Fr: Simon Davis
Sent: 06 October 2014 14:17
To: 'Peter Champion'
Subject: RE: BR/71/12 - preparing NMA & DOC applications

Plot 3 - Floor Plans
Plot 2 as plot 3 but handed

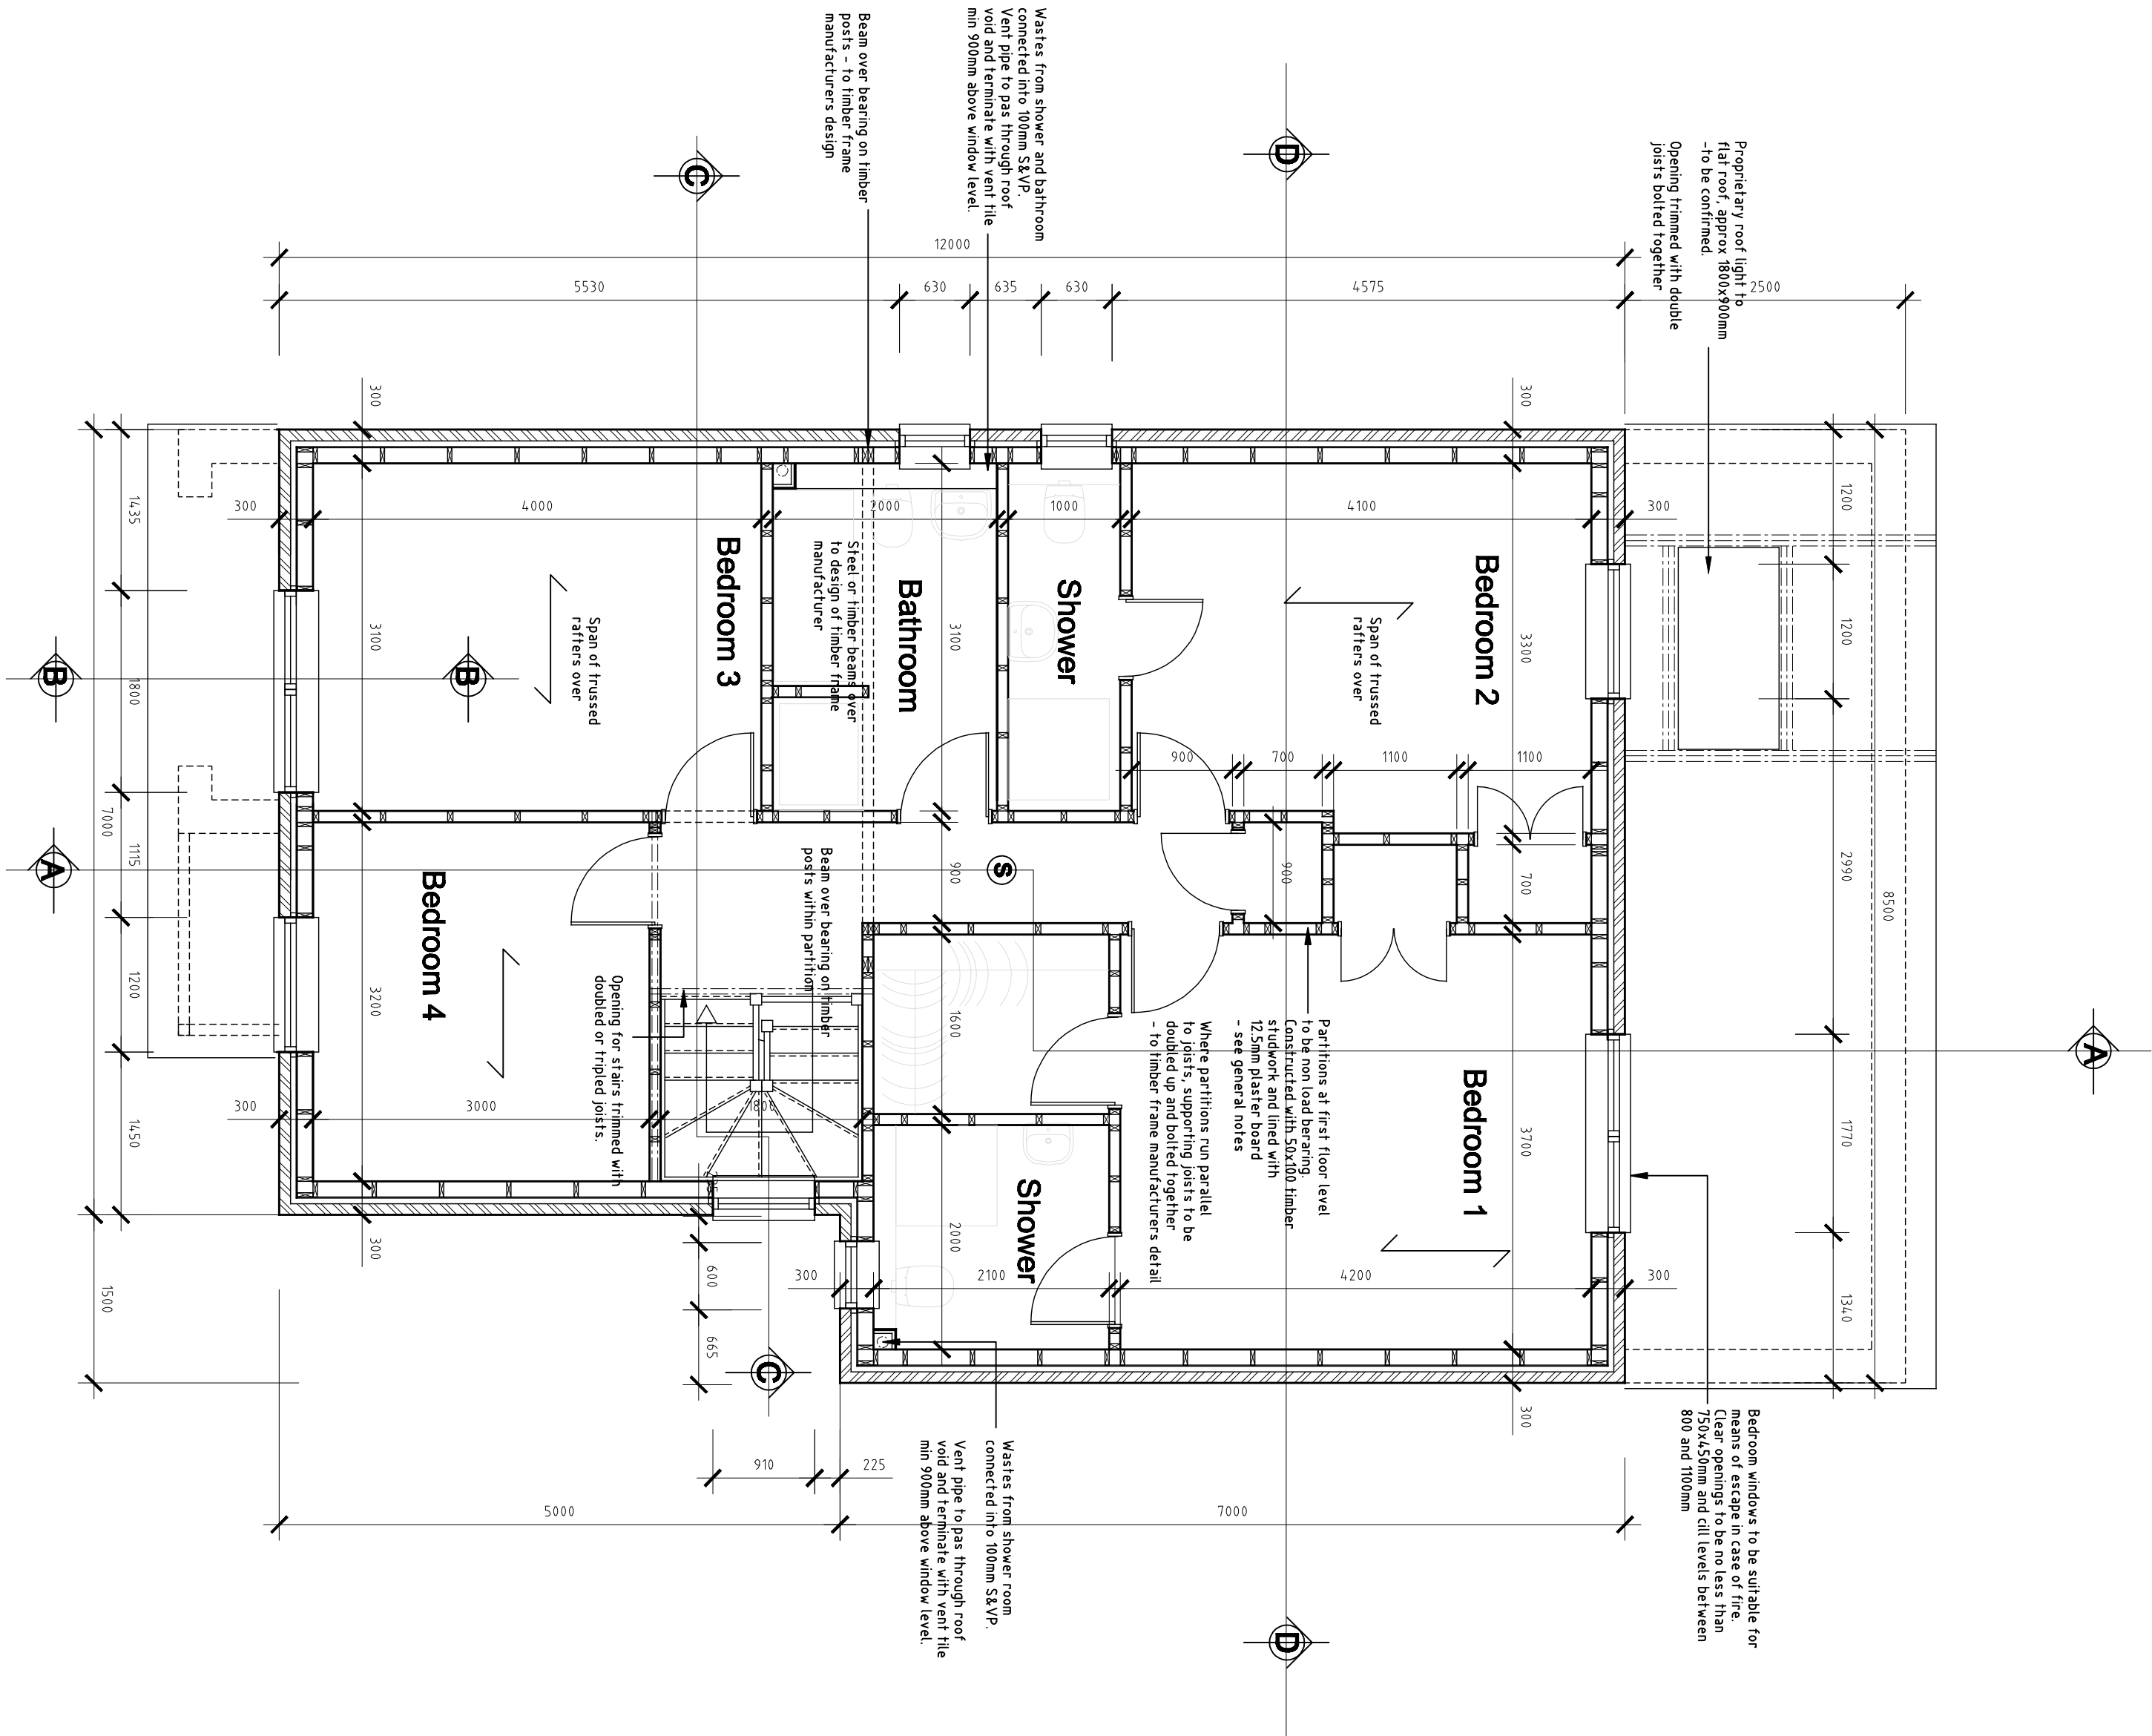
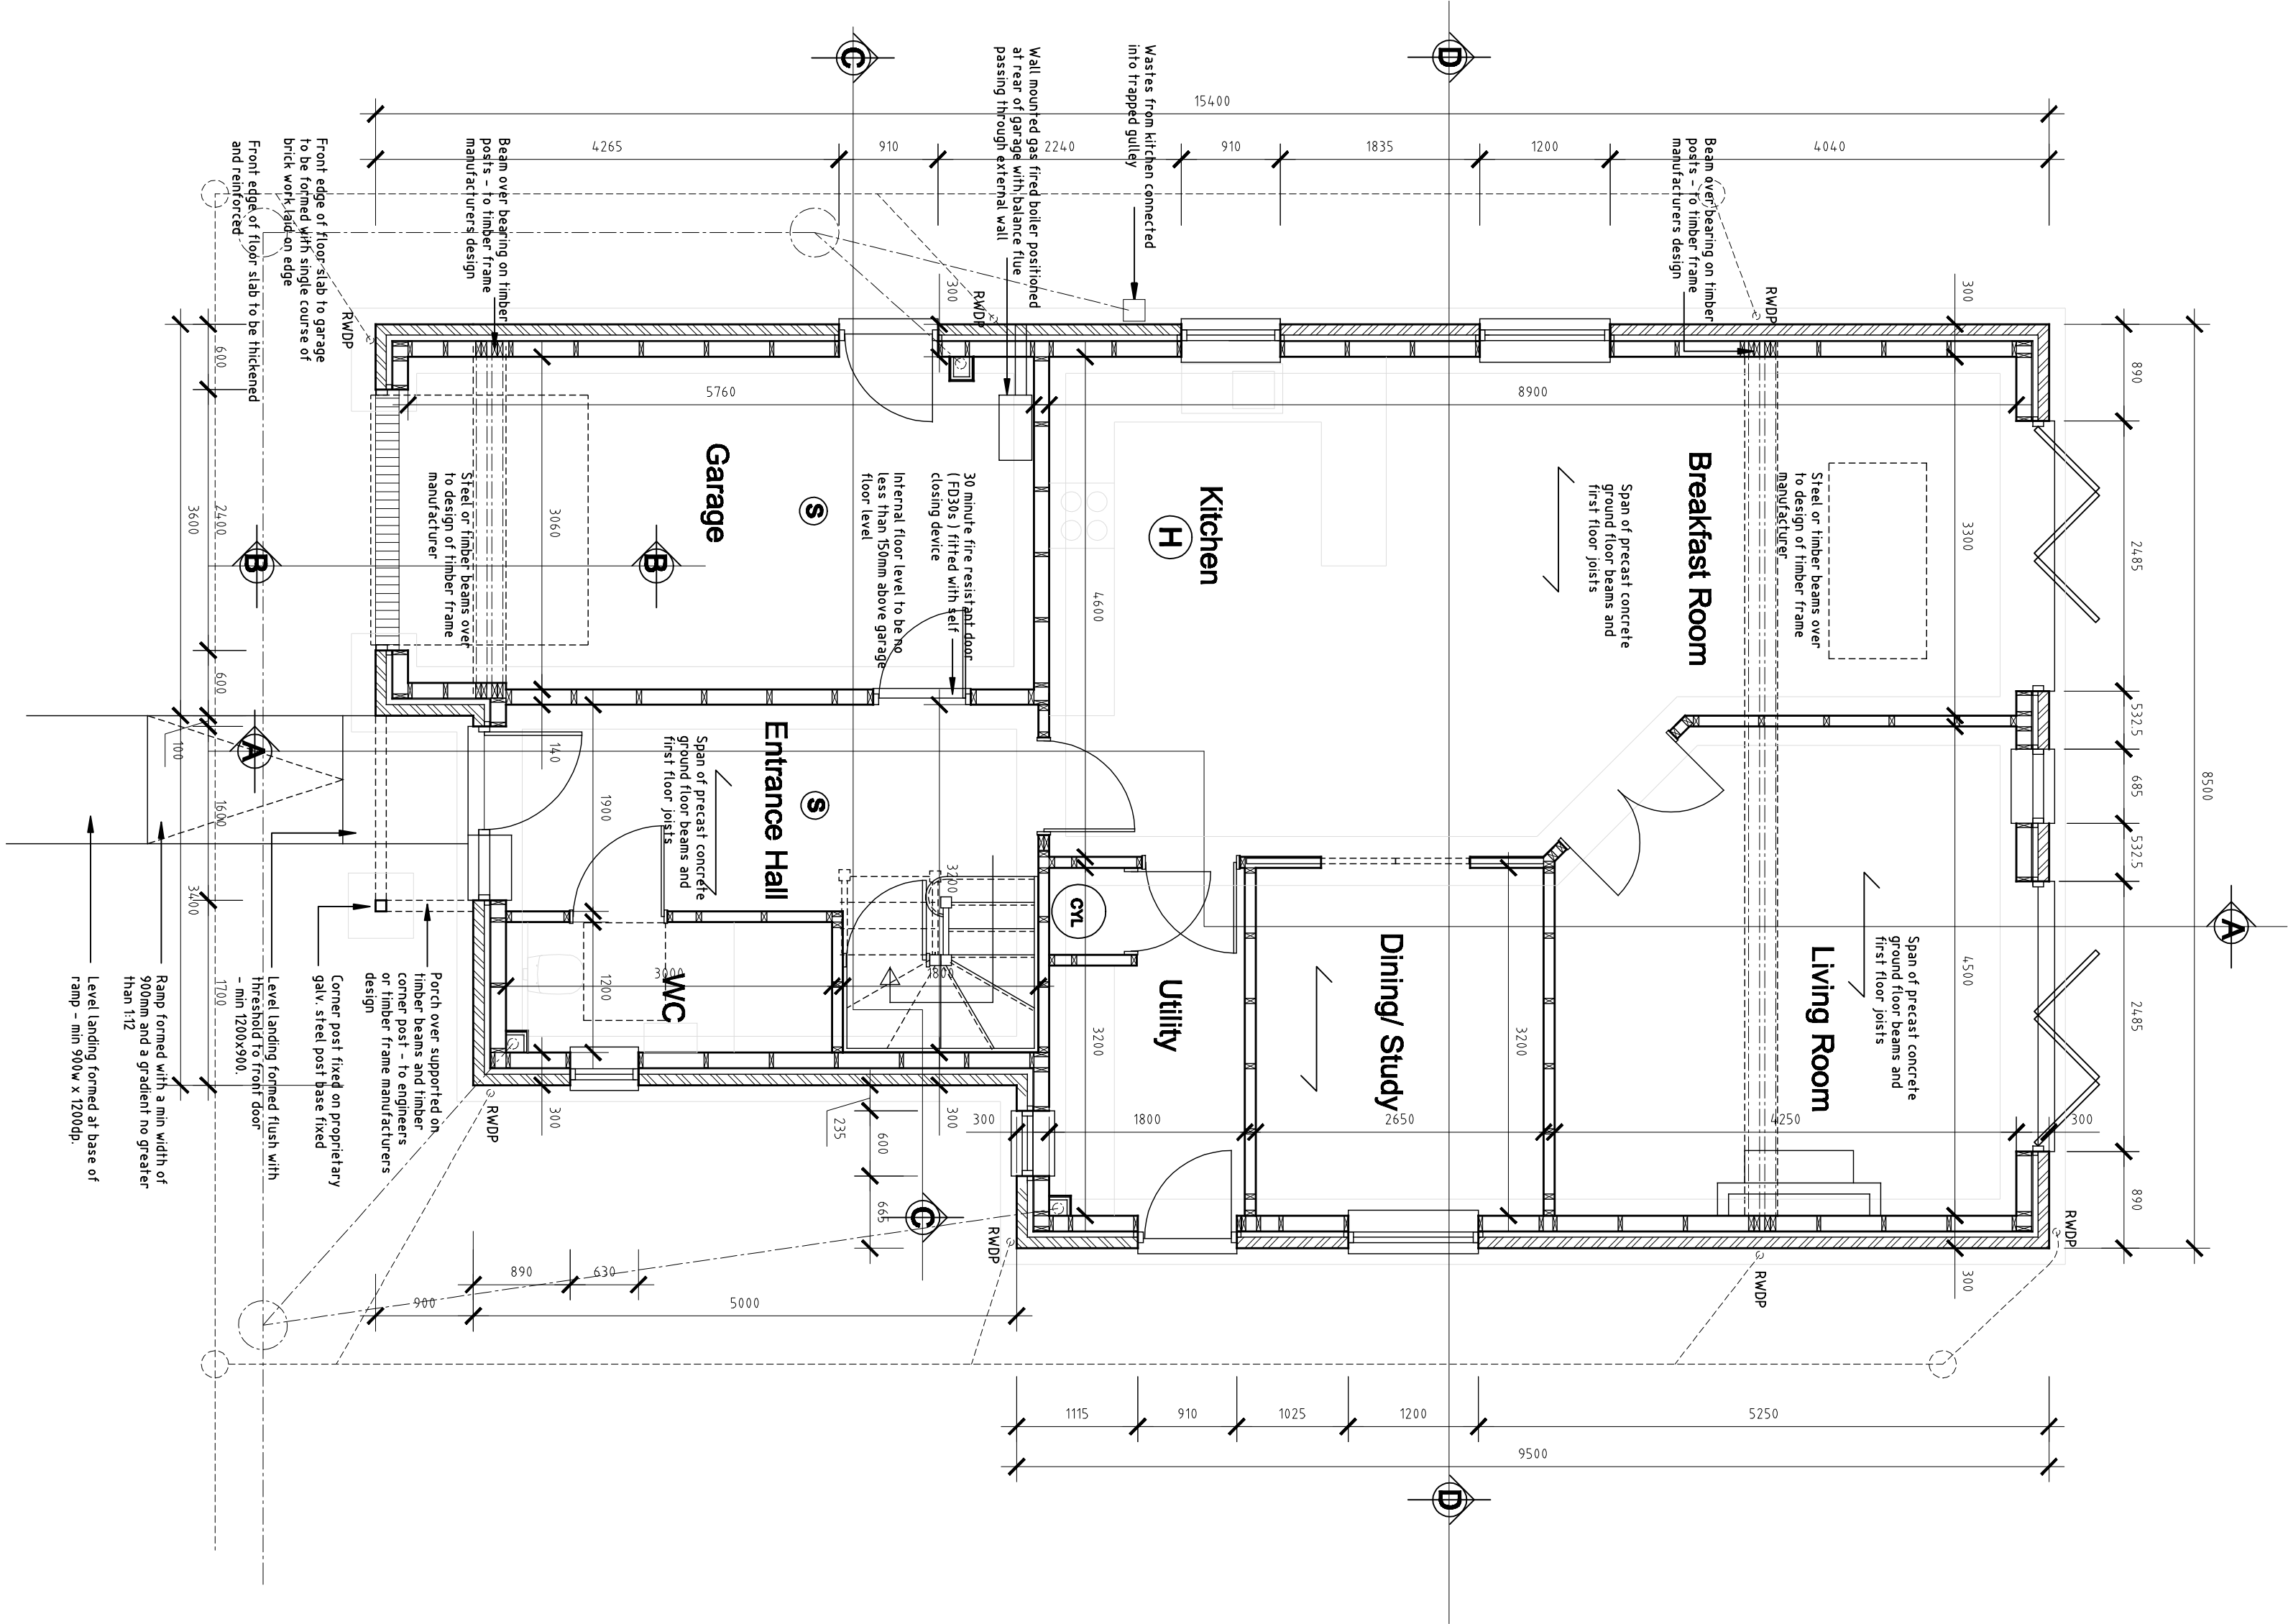
PLOT 3 - No new flat windows, avoidance to GF roofline - less windows

PLOT 2 - As above
